KITTITAS COUNTY

DEPARTMENT OF PUBLIC WORKS

MEMORANDUM

TO: All Staff
FROM: Public Works Plan Review Team
DATE: August 25, 2021
SUBJECT: LPF-21-00006 Forest Ridge II

DWN BY	DATE	JOB NO.
T.S.	09/2021	18069
CHKD BY	SCALE	SHEET
M.K.K./D.L.P.	N/A	1 OF 7

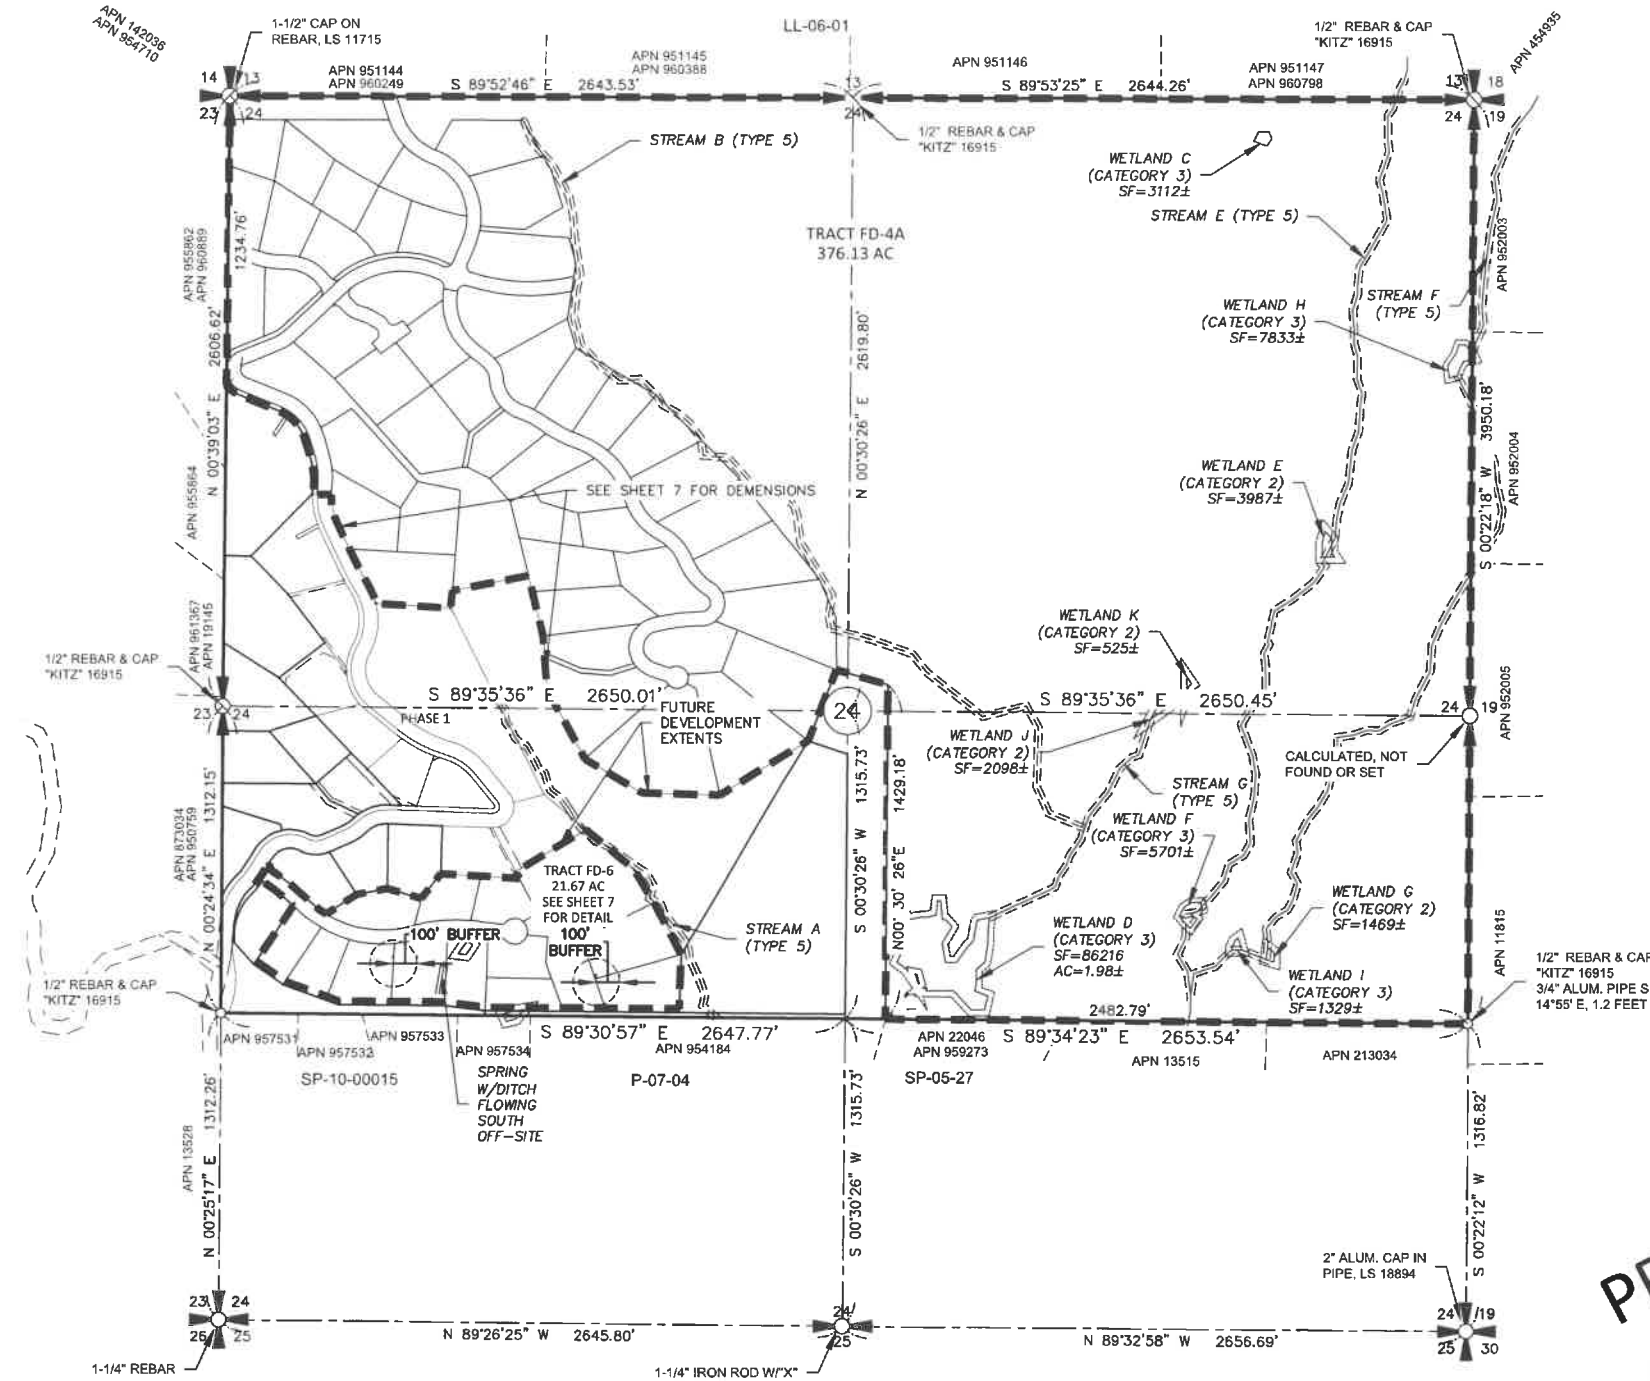
1. Change CDS and Assessor approvals to reference "Forest Ridge-Phase II".
2. Update Existing Kittitas County Parcel and (Map Numbers) prior to final recording.

DWN BY	DATE	JOB NO.
T.S.	09/2021	18069
CHKD BY	SCALE	SHEET
M.K.K./D.L.P.	1" = 500'	3 OF 7

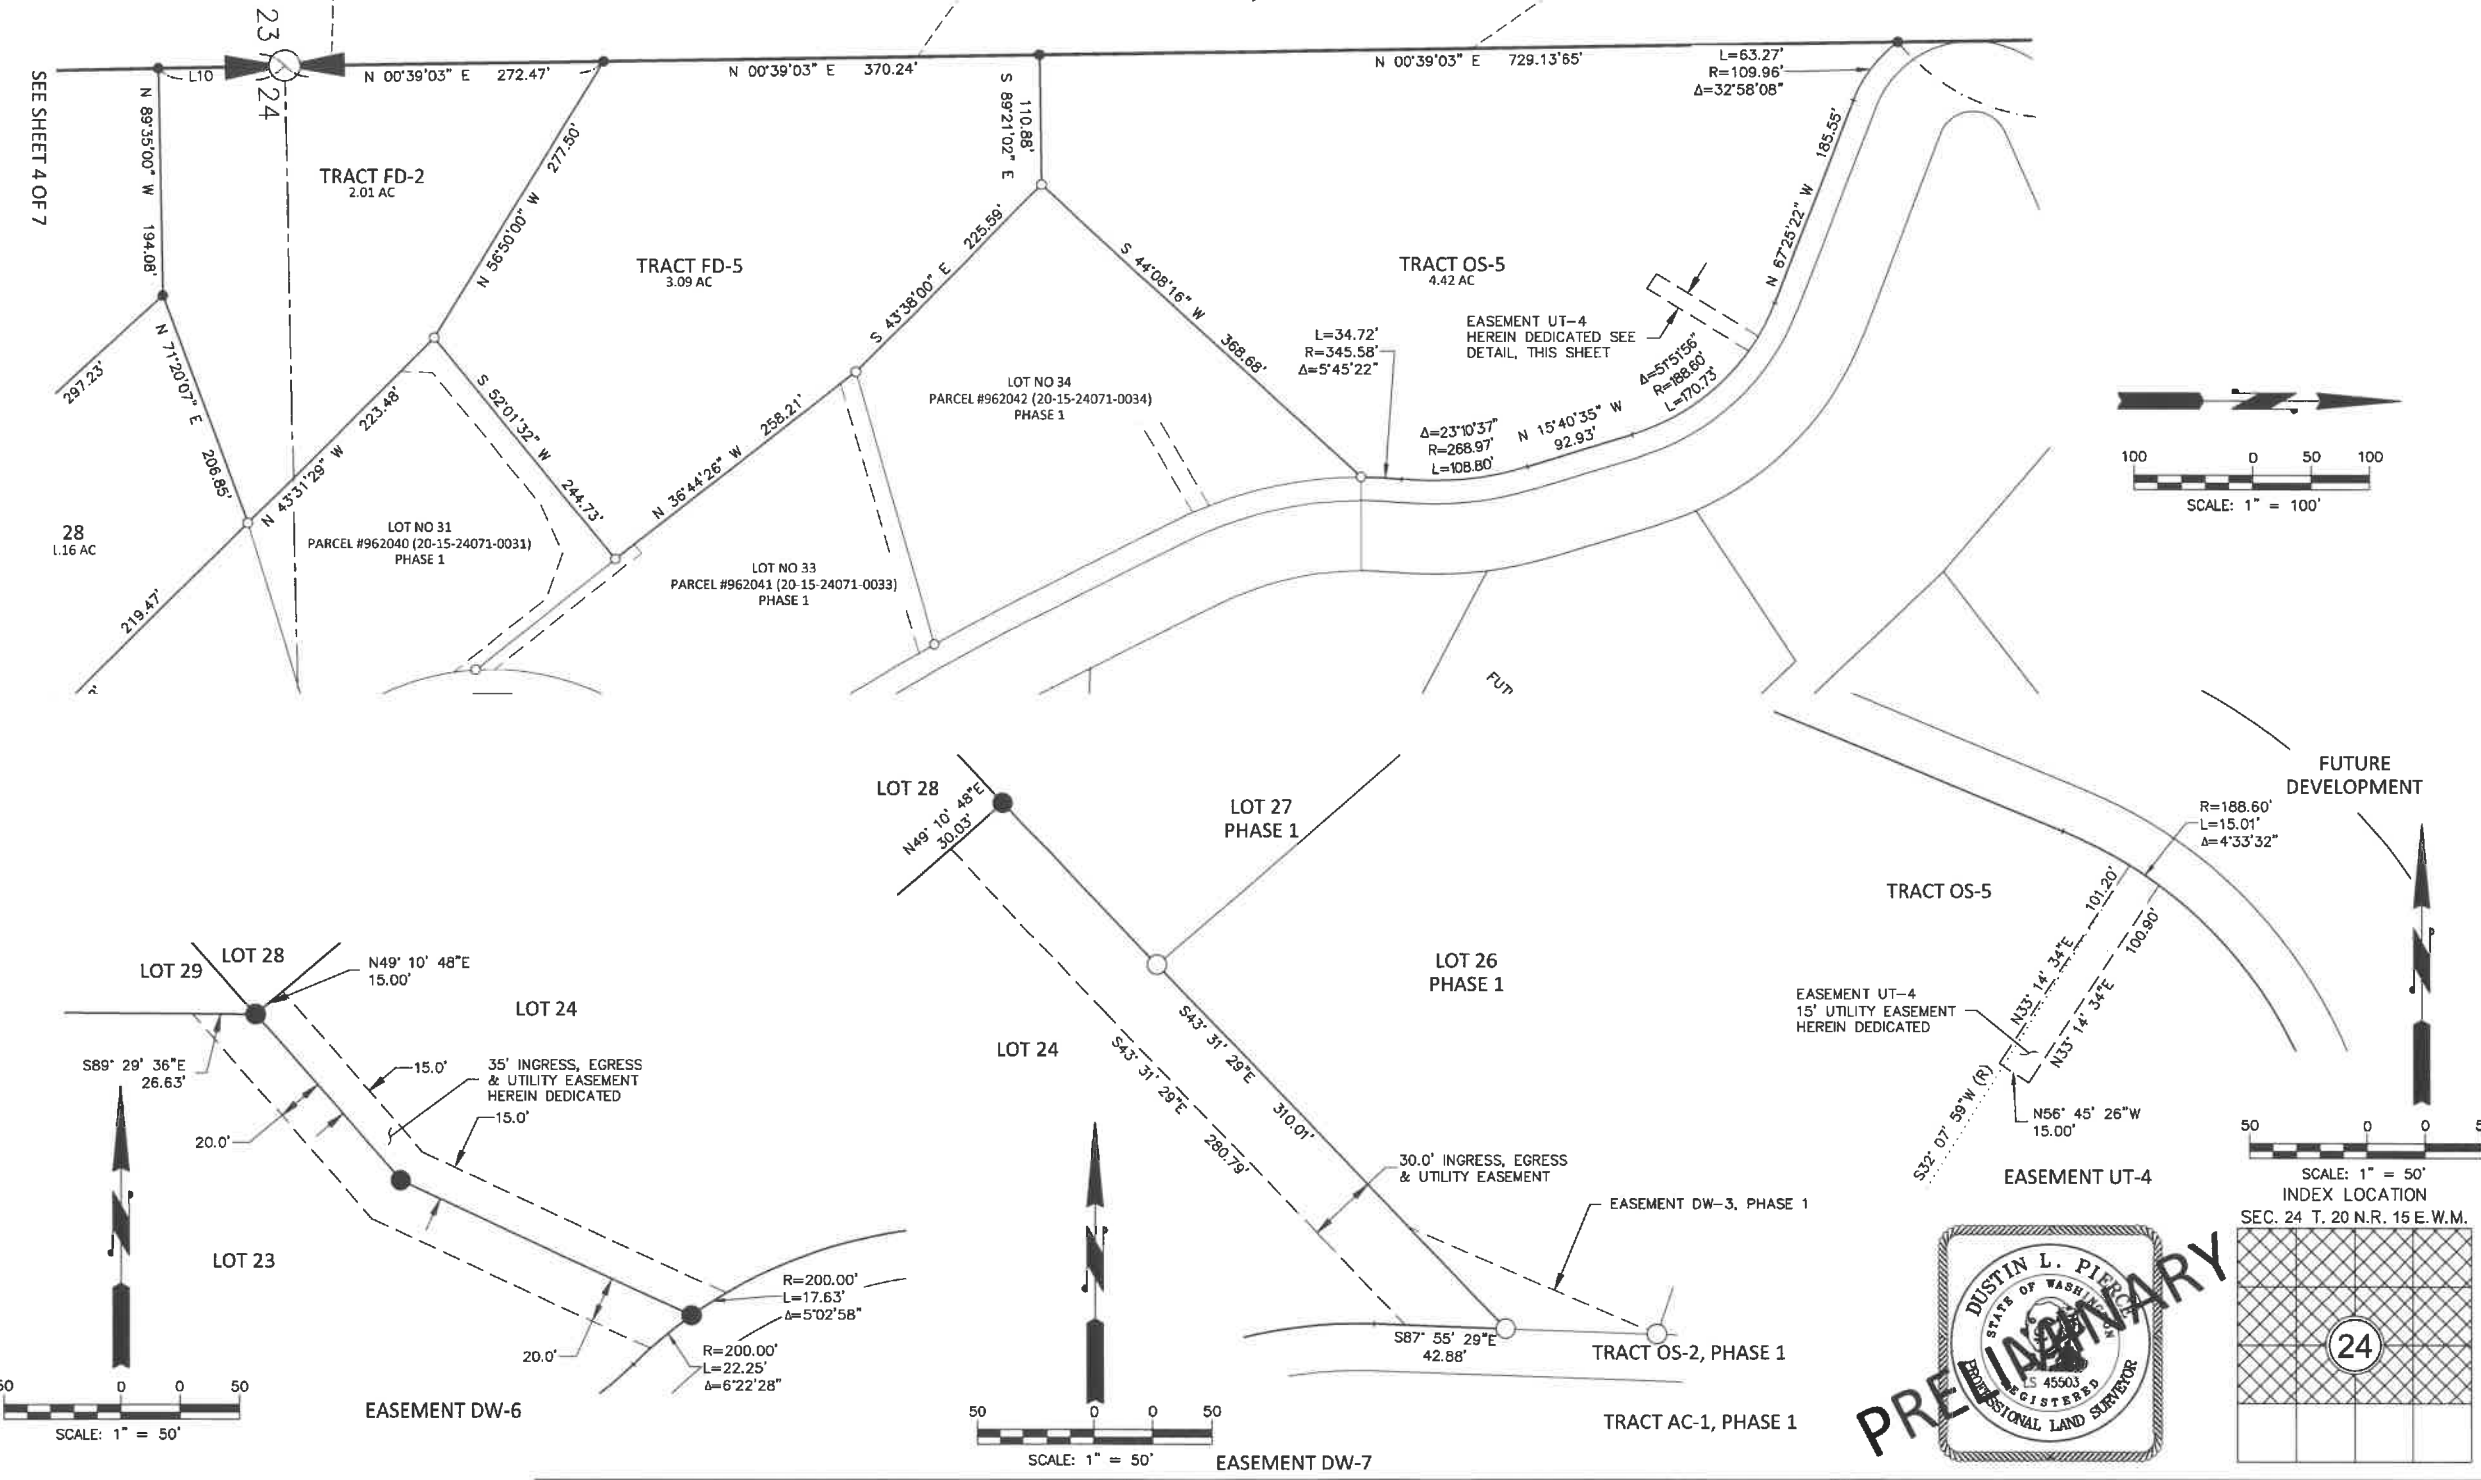
3. Tract FD-4 AND Tract FD-6 are not dimensioned.

DWN BY	DATE	JOB NO.
T.S.	09/2021	18069
CHKD BY	SCALE	SHEET
M.K.K./D.L.P.	1" = 100'	6 OF 7

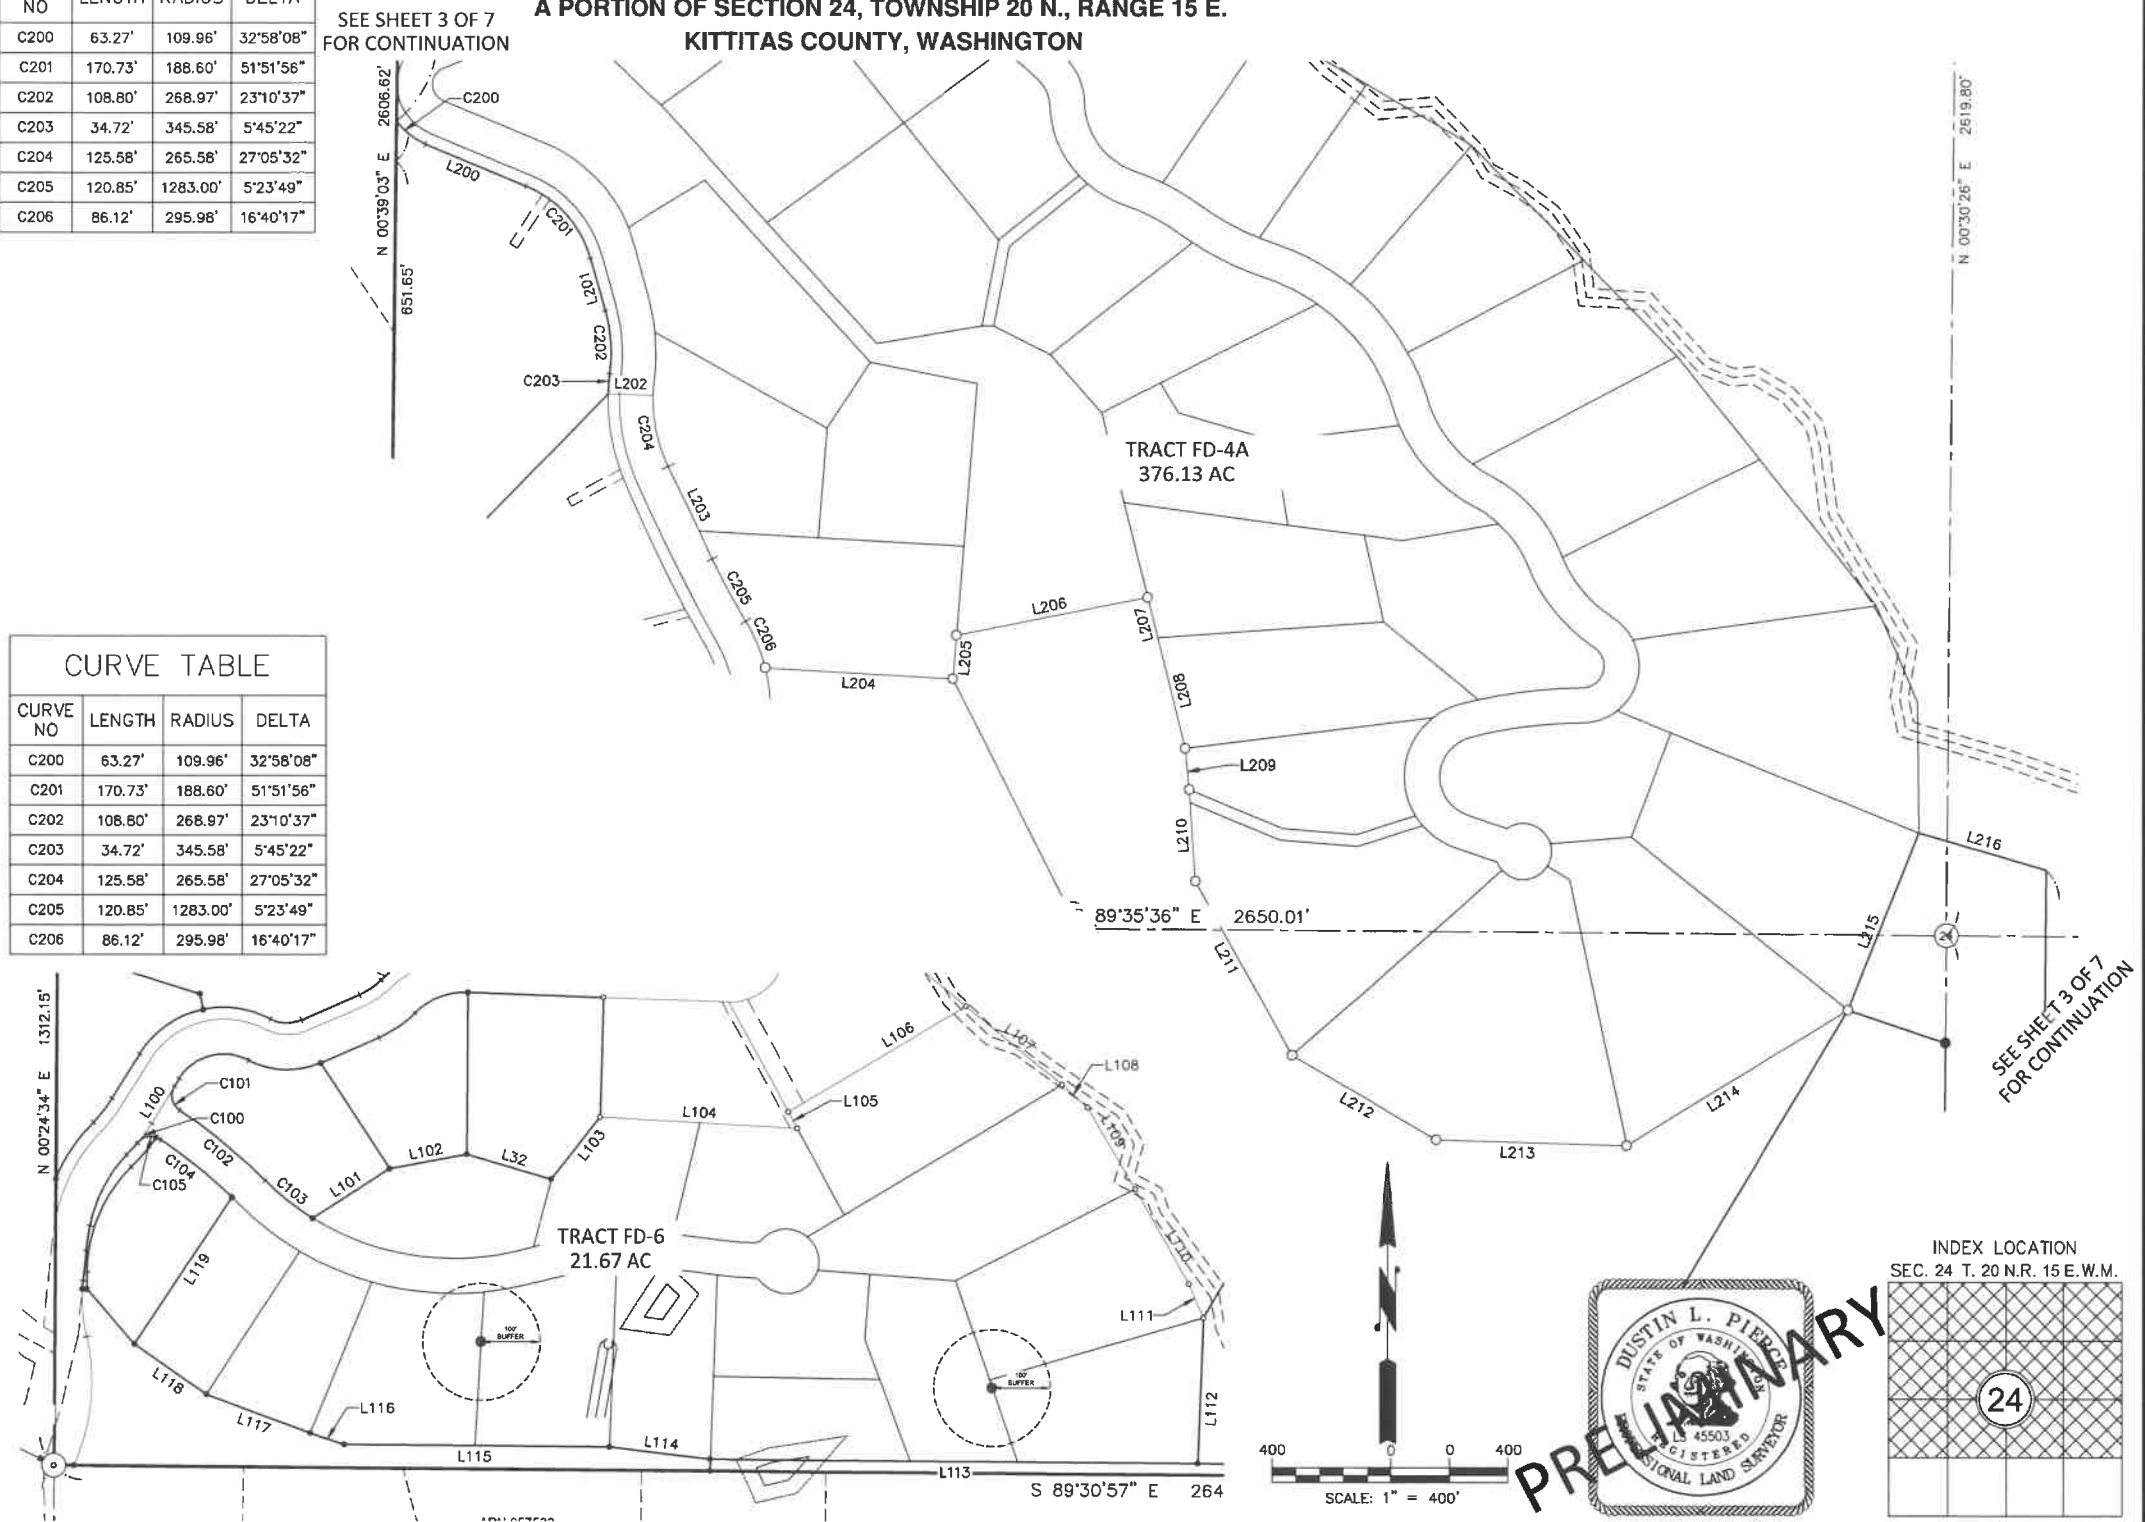
5. The area for Tract FD-2 is obscured by crossing linework.
